Our Ref: C19/696

11 December 2019

RE: Port Kembla Gas Terminal Modification (SSI 9471 MOD 1)

**FSRU cross section showing location of seawater intakes**

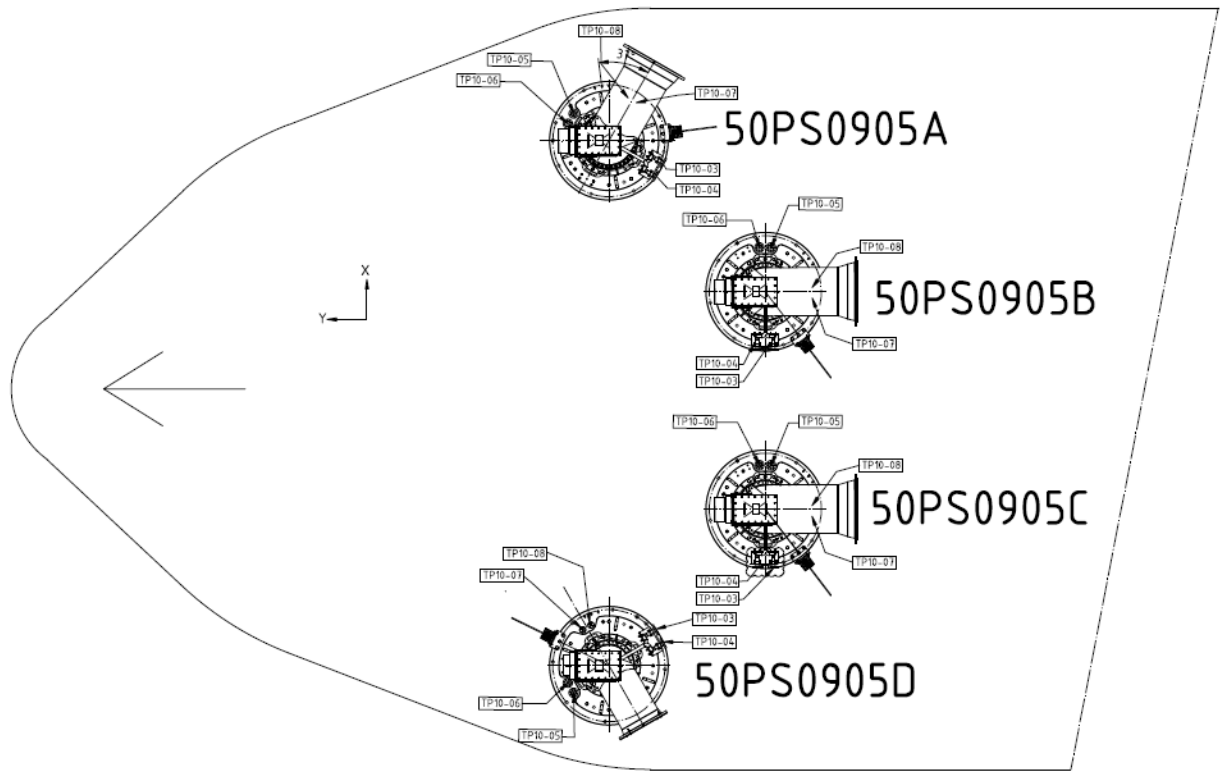
1. An assessment of the potential for entrainment of aquatic organisms and plankton in the water intake system is conducted prior to any authorisation of this project amendment. This is to include information on the potential scale of impact, proposed measures to mitigate such impact and the approach velocity close to the intake screen; and
2. DPI Fisheries be consulted to review the plans of the water inlet structure during the detailed design stage.
